CITY OF ALBUQUERQUE

July 9, 2020

**Re: Menaul Retail
Project Address
Traffic Circulation Layout, Certificate of Occupancy
BP 2019-34287
H19-D040**

SHEET NUMBER
AS-1.0

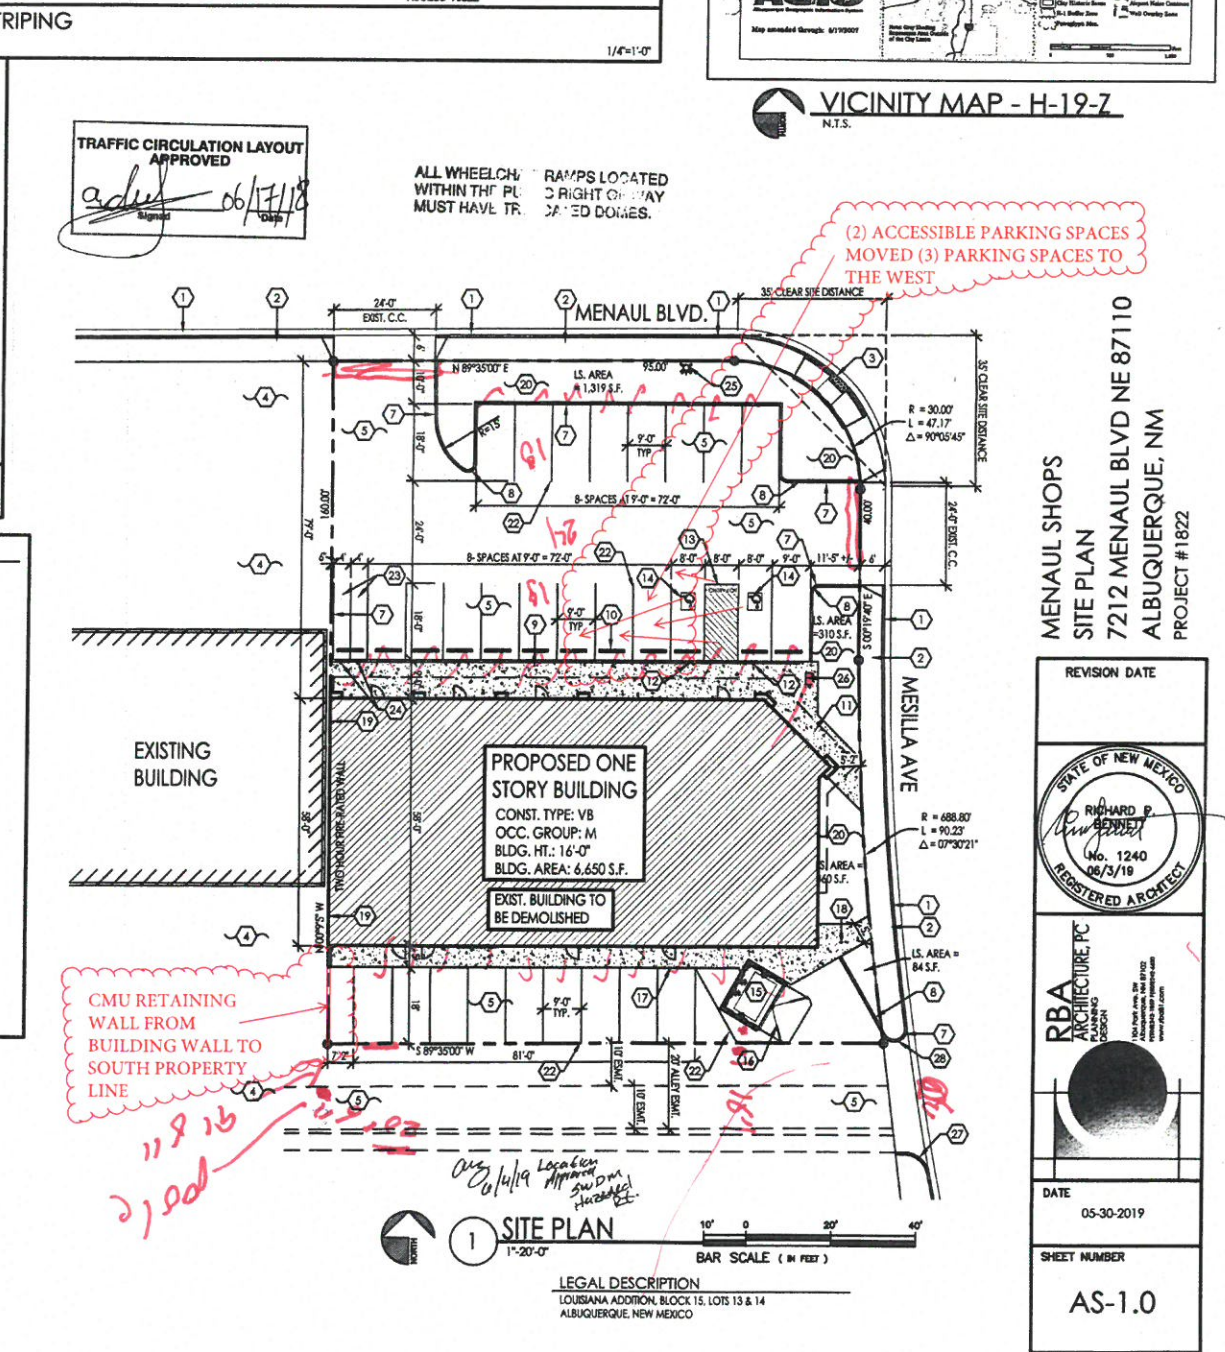
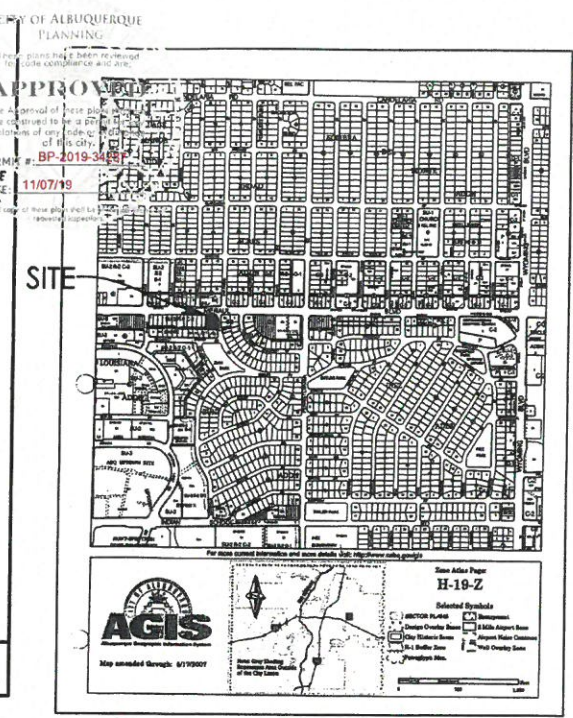
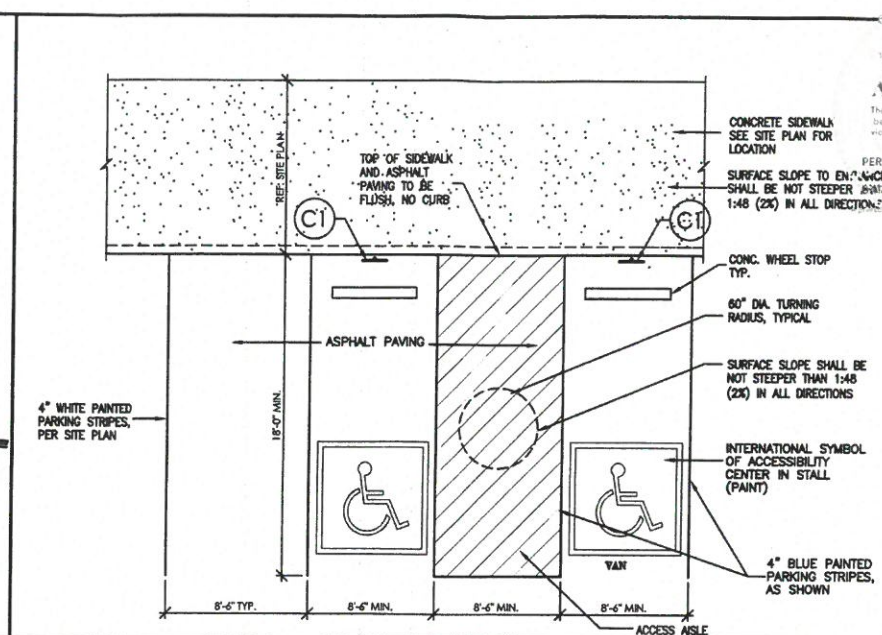
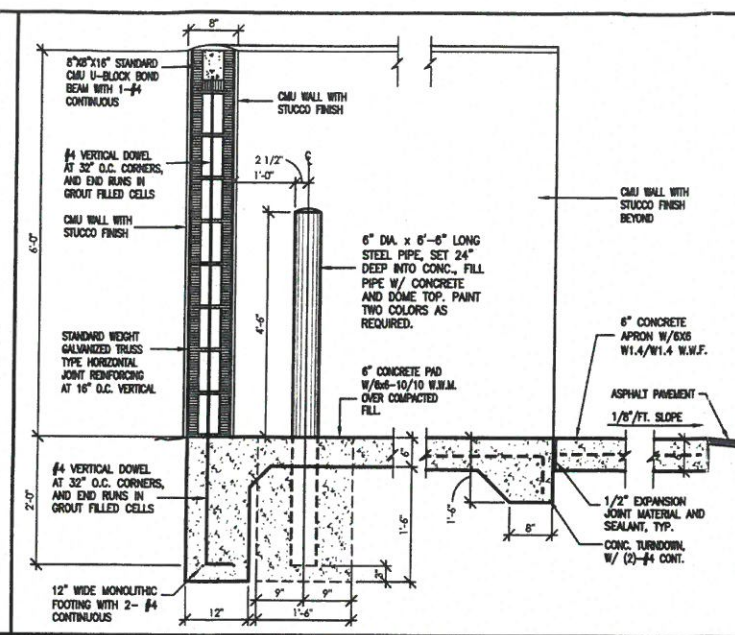
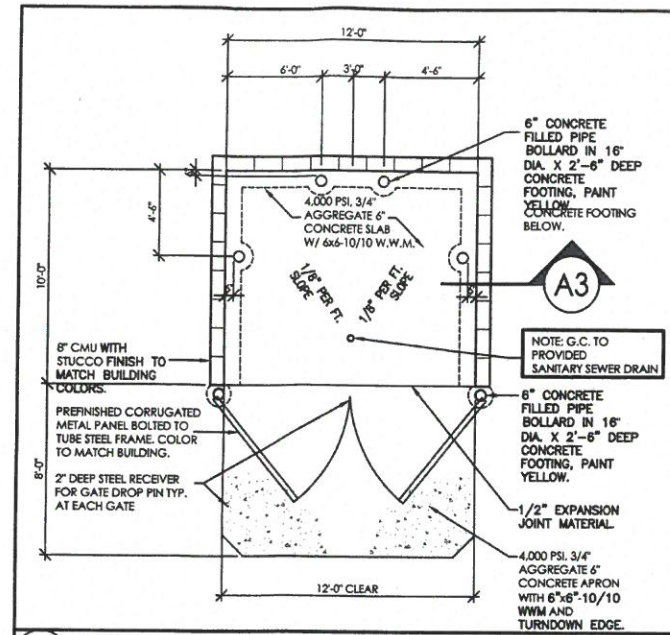
Both the Traffic Circulation Layout and the Grading and Drainage Plan did not identify the existing powerpole nor did the originally approved Traffic Circulation Layout identify the new wall. It is the designer's obligation on a Traffic Circulation Layout Plan to identify any existing and new infrastructure that would interfere with vehicular and pedestrian travel, particularly when one is building adjacent to a road or using public right-of-way for access to parking spaces. A combination of the new wall along with the existing powerpole on the Traffic Circulation Layout Plan would have clearly identified that there is a conflict that only allows less than 10 feet of vehicular travel within the alleyway.

Even if it is argued that vehicles could come in from the west side, there is no legal easement that would provide a turn-around for larger trucks such as Solid Waste Vehicles or Delivery Trucks that are frequently using the alleyway. The current set-up with blocking off alleyway access from the east side is completely unacceptable.

Secondly, the alleyway is public right-of-way. Therefore, any placement of bollards around the existing powerpole and paving of the alleyway as part of this project should have gone through the work order process. If this process was followed, this was another opportunity for the city engineers to look at the design of the public alleyway and catch any issues that affected Transportation Department and Hydrology
